**Consultation Response from KC,
Highways Development Management**

2026/91280 Hardingley Farm, Copley Lane, Shelley, Huddersfield, HD8 8LZ

Date Responded: 15/09/2023

Responding Ref: K12-47/17

| Drawing No. | 2610 - 0304 - P02 |

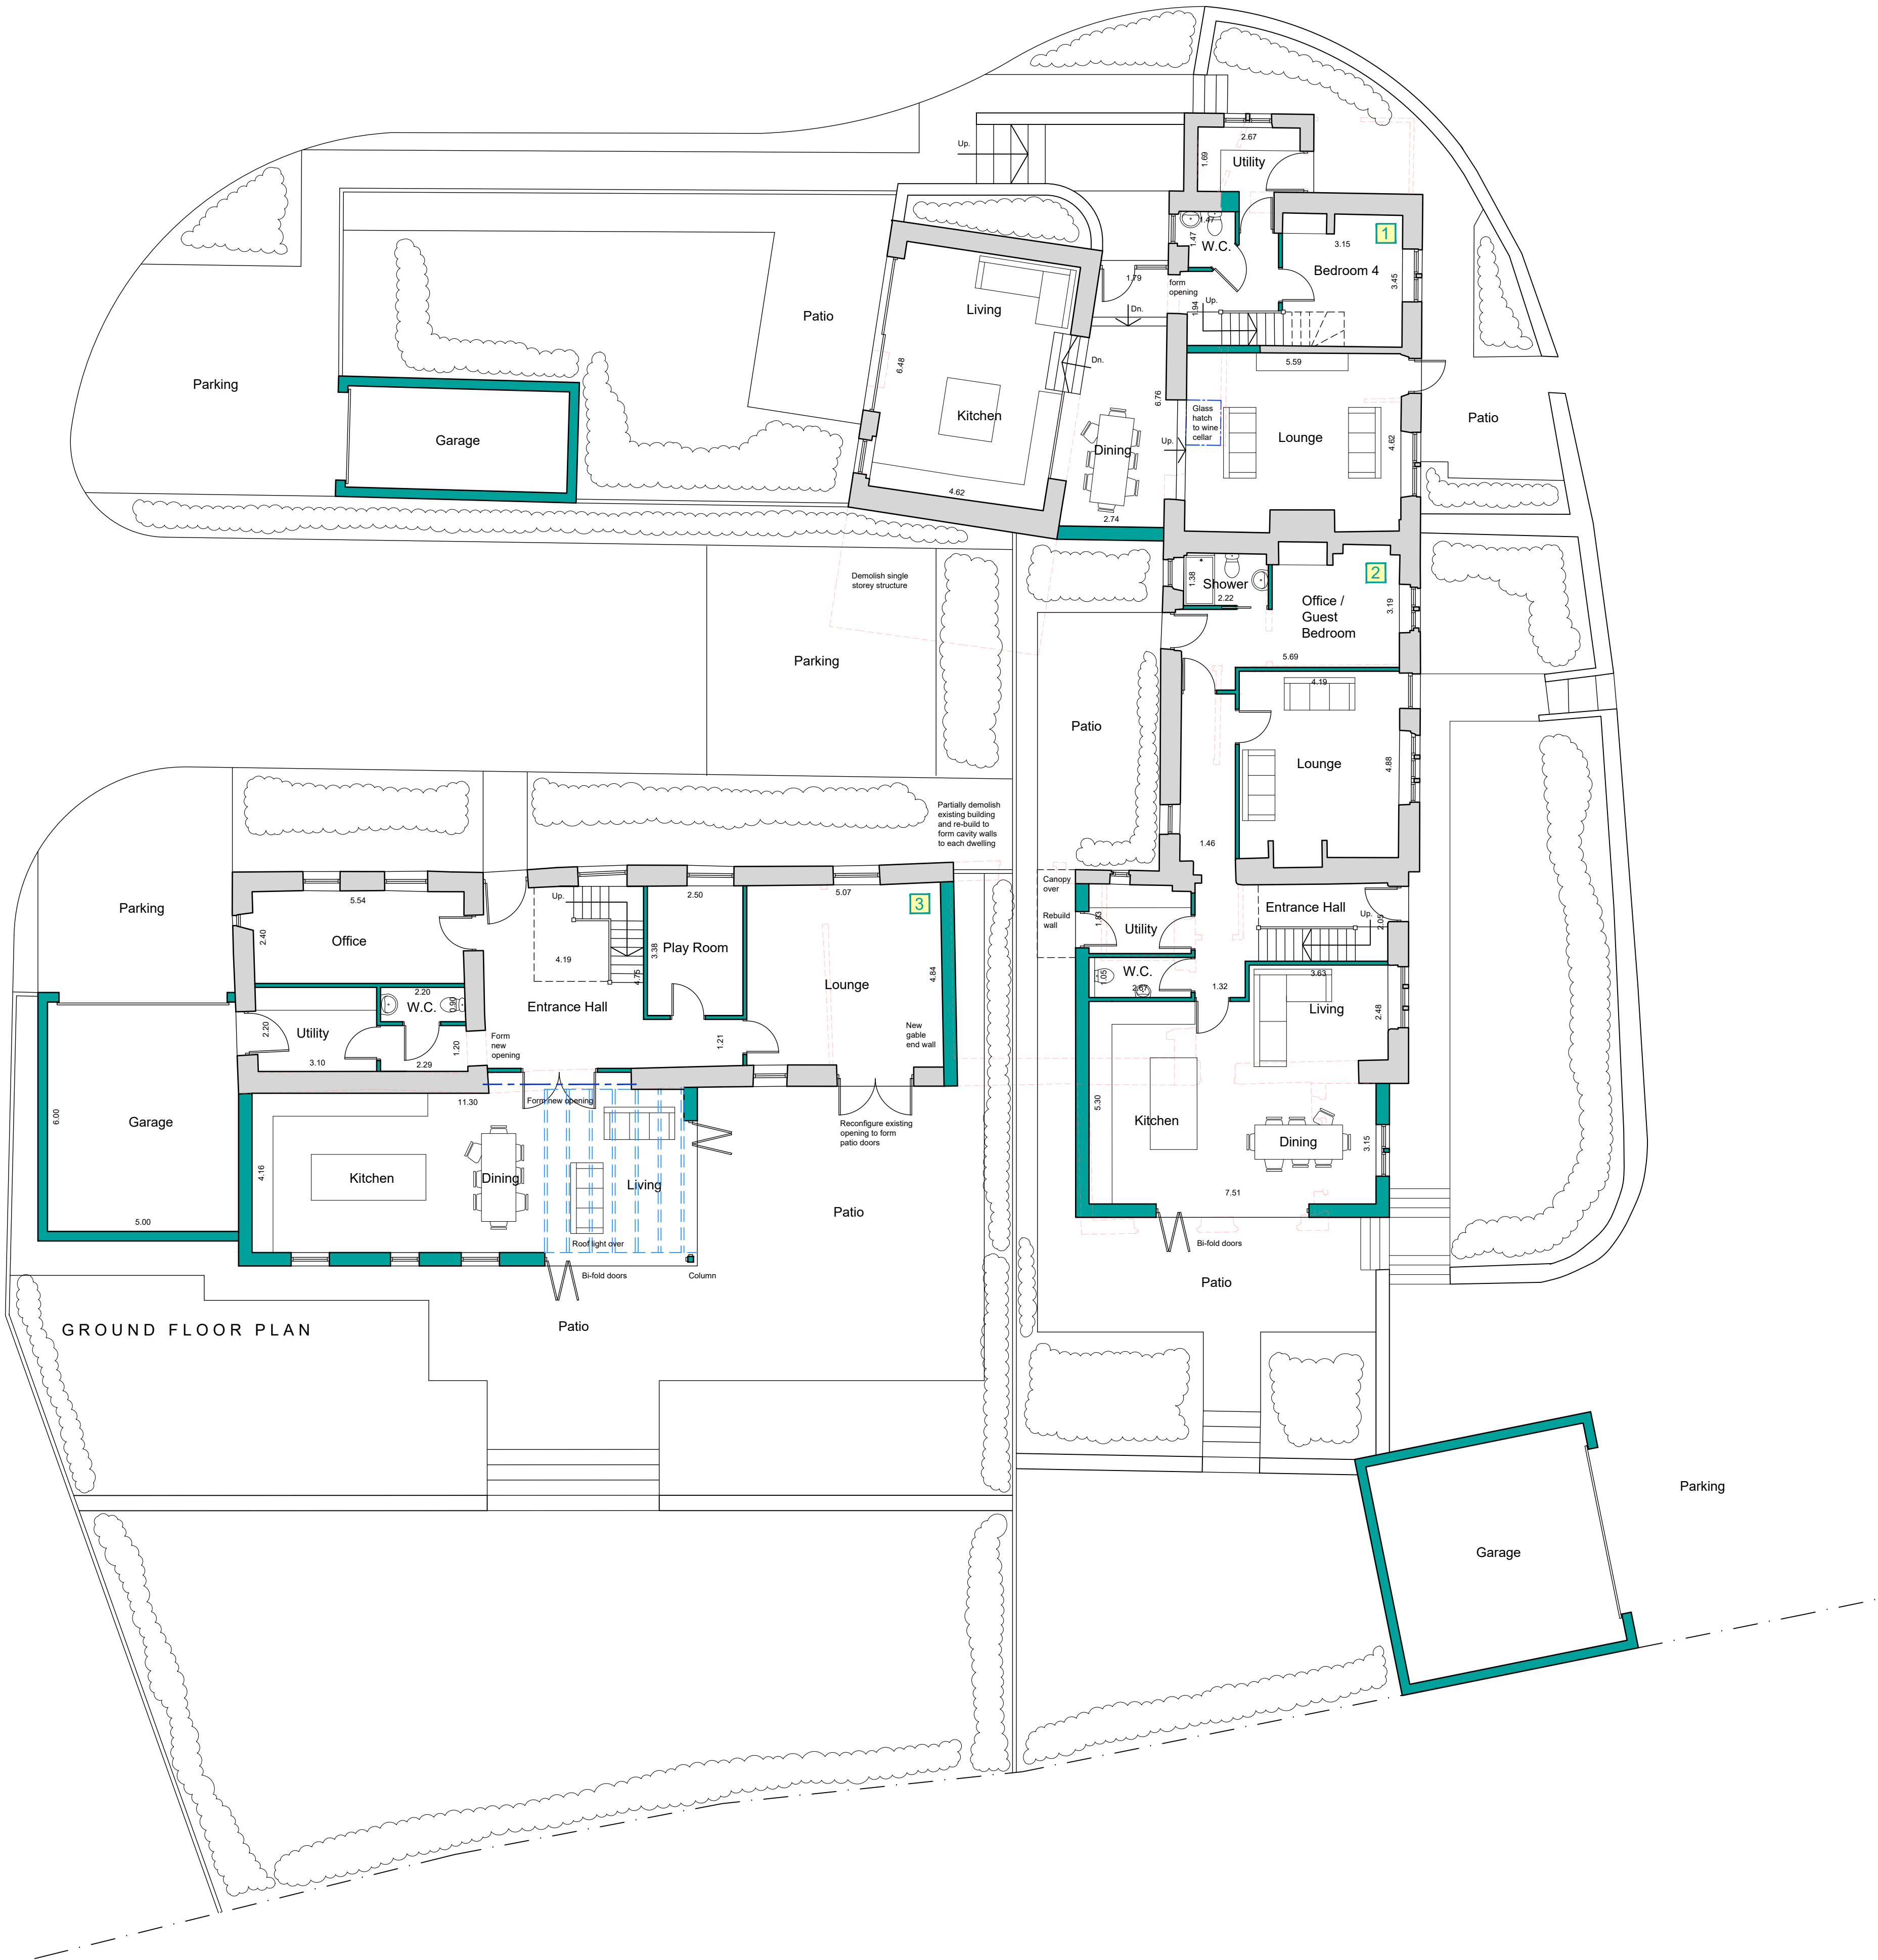
An inspection of the site layout drawing 25110-0301-P02 indicates that there is sufficient driveway space marked to park 2 cars at plot 1, 2 cars at plot 2 (although care must be taken not to obstruct the PROW), 4 cars at plot 3, 3 cars at plot 4 and 3 cars at plot 5. Plans 2610-0304-P02 (plots 1-3), 25110-0302-P03 (plot 4) and 2511-0303-P01 (plot 5) show internal garage sizes.

The garage in plot 1 has internal dimensions below those required in local guidance (3m x 6m) with scaled dimensions of 2.6m x 5.6m. This would not be classed as a parking space and so plot 1 would be below local standards for parking and an additional space will need to be indicated.

The garage in plot 2 scales to 6m x 5.7m and is suitable for a double garage. This makes the parking at plot 2 acceptable.

The garage in plot 3 scales to 6m x 5m and would only be suitable as a single parking space with storage. This makes the parking at plot 3 acceptable.

These additional car parking requirement for plot 1 and visitor parking look like they can be easily provided and so we would be happy to have these conditioned with suggested wording provided.

Drawn DRH
Date April 2026
Scales 1:100 @ A2
Drawing No. 2511 - 0303 - P01

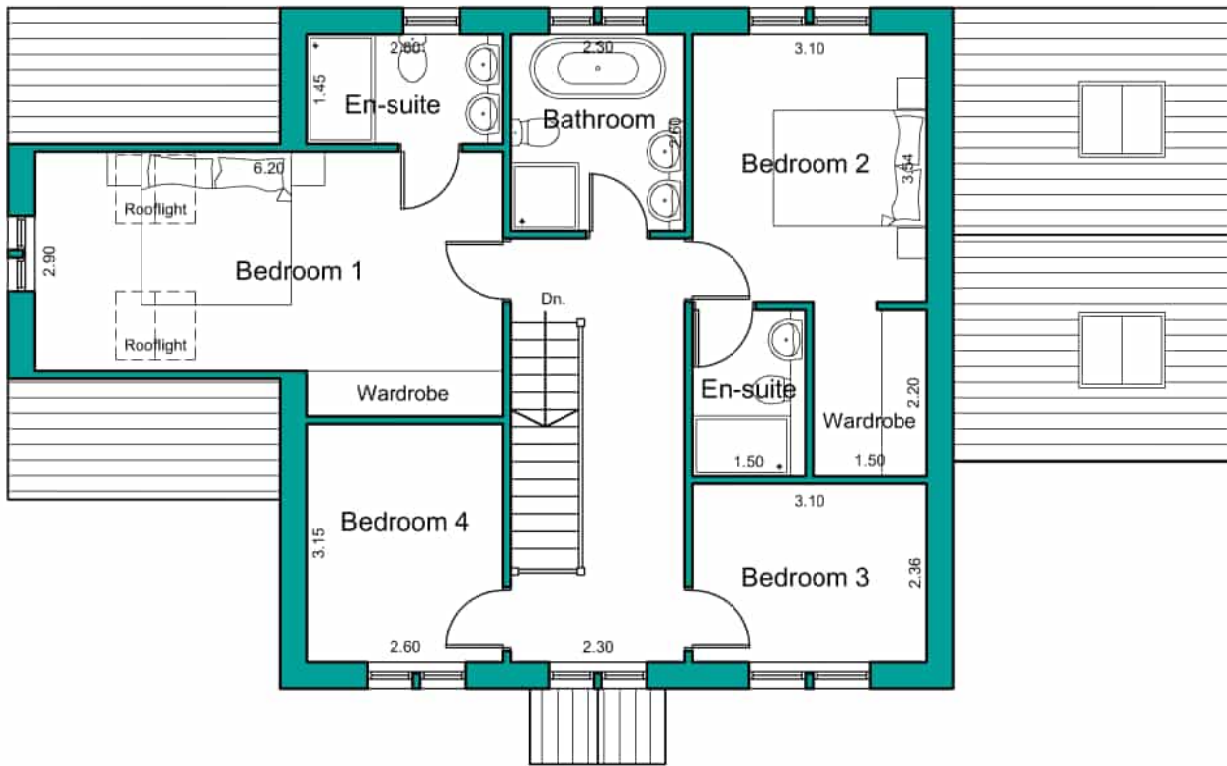
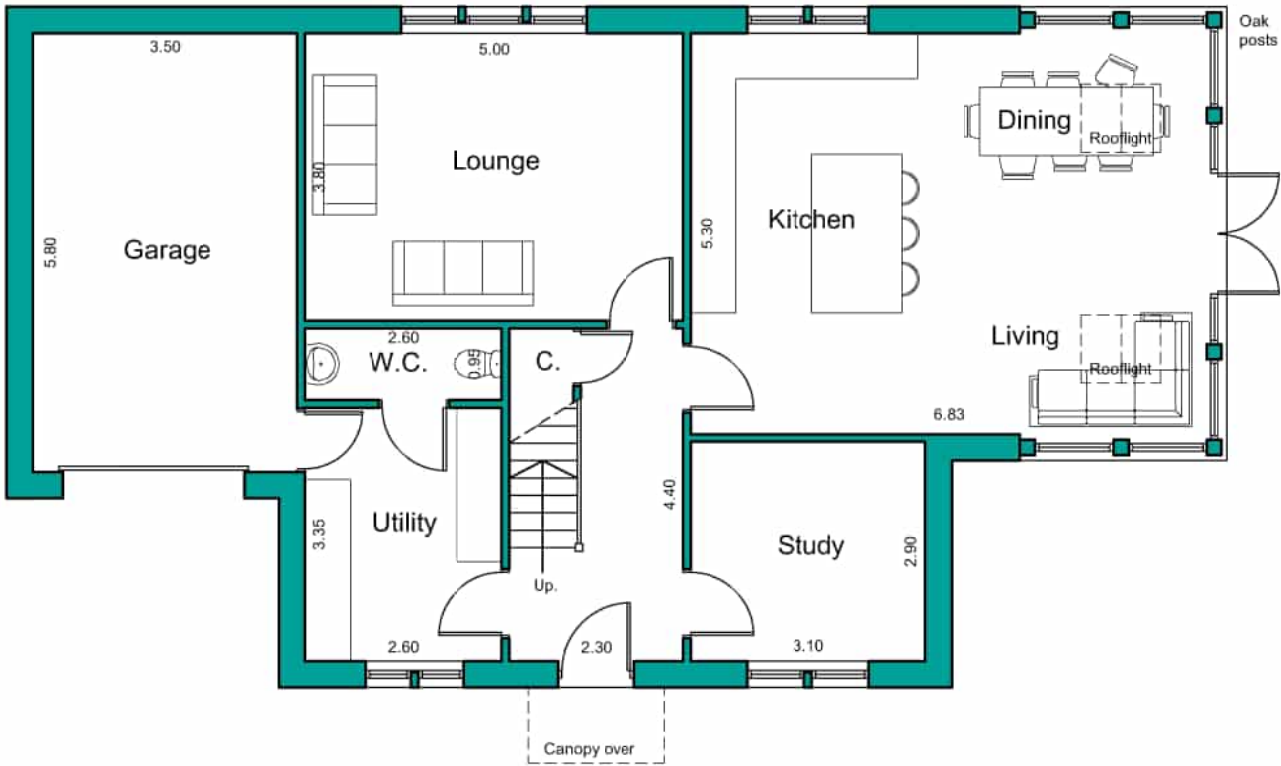
The garage in plot 5 scales to 6m x 3.5m which would be suitable as 1 parking space. This makes the parking at plot 5 acceptable.

Drawn	DRH
Date	April 2026
Scales	1:100 @ A1
Drawing No.	25110 - 0302 - P03

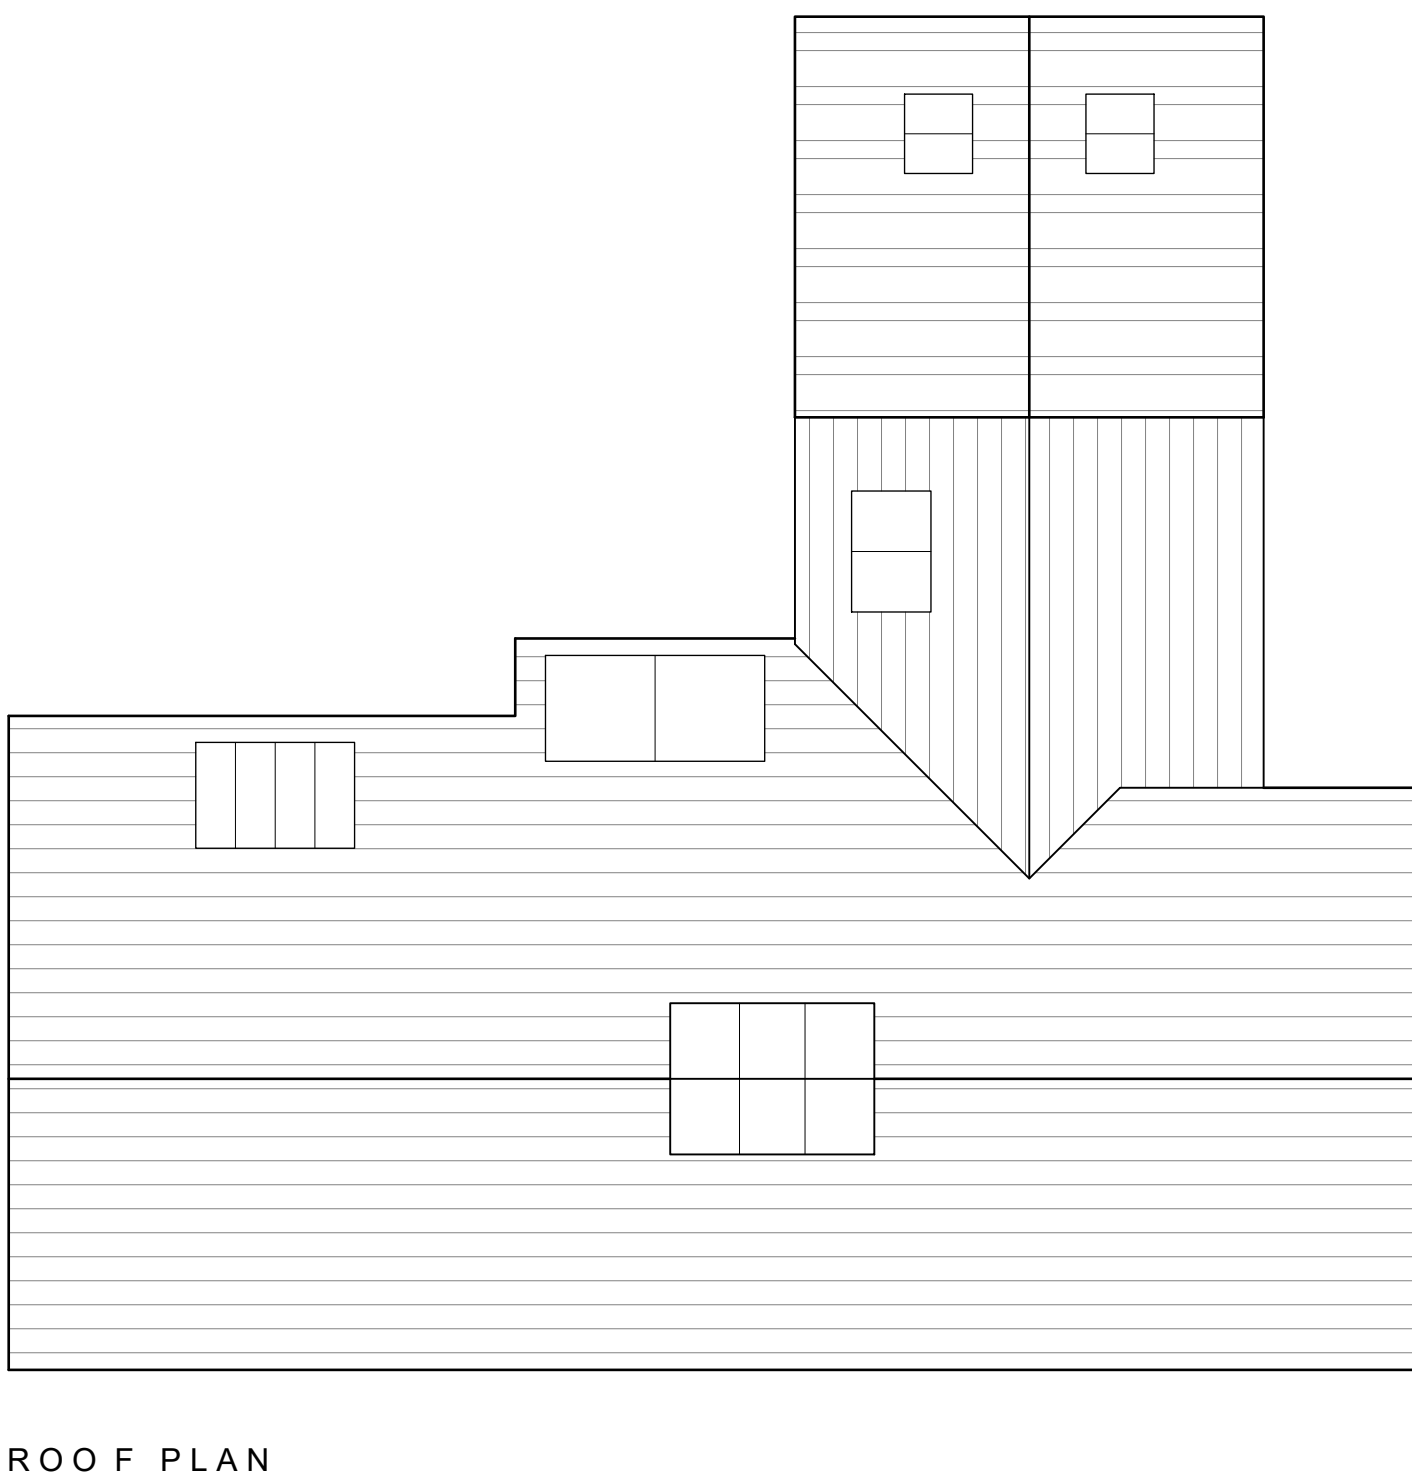
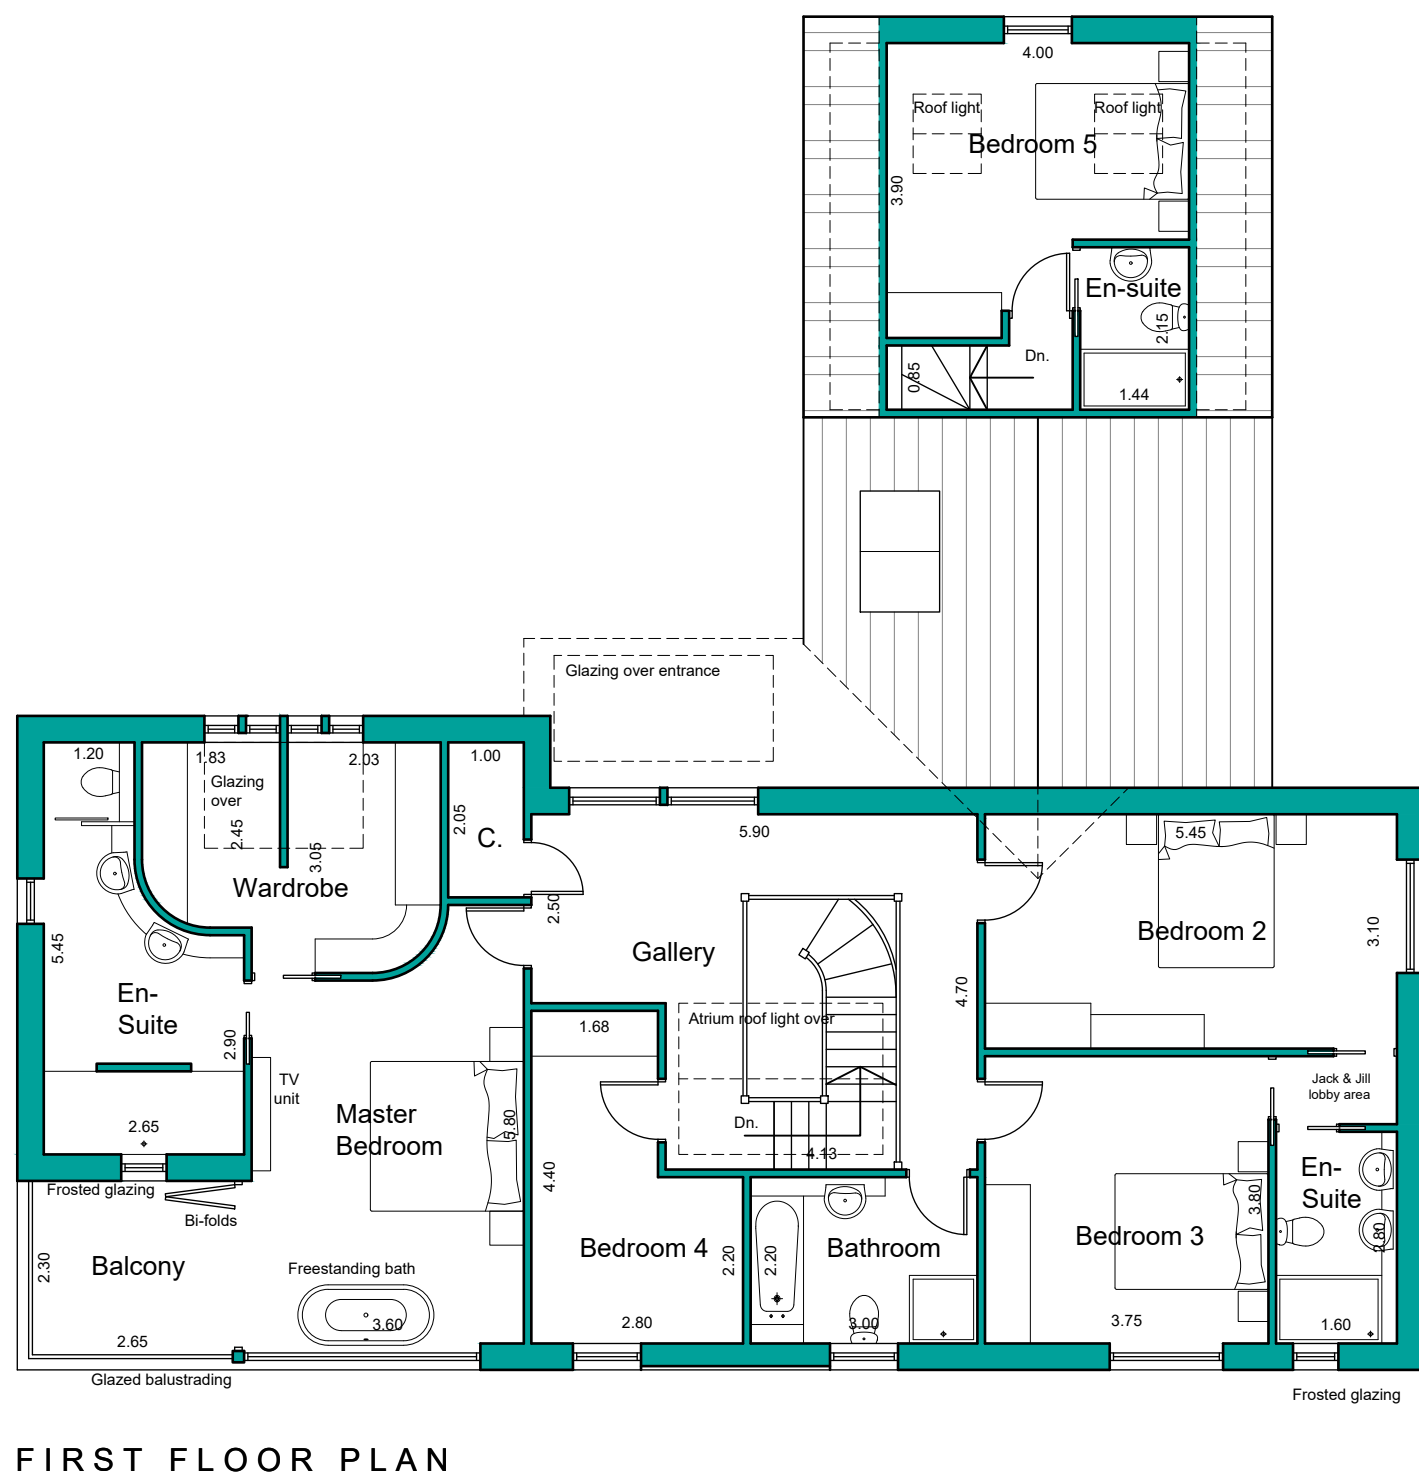
The garage in plot 4 scales to 6m x 5.3m and would be suitable as 1 parking space plus storage. This makes the parking at plot 3 acceptable.
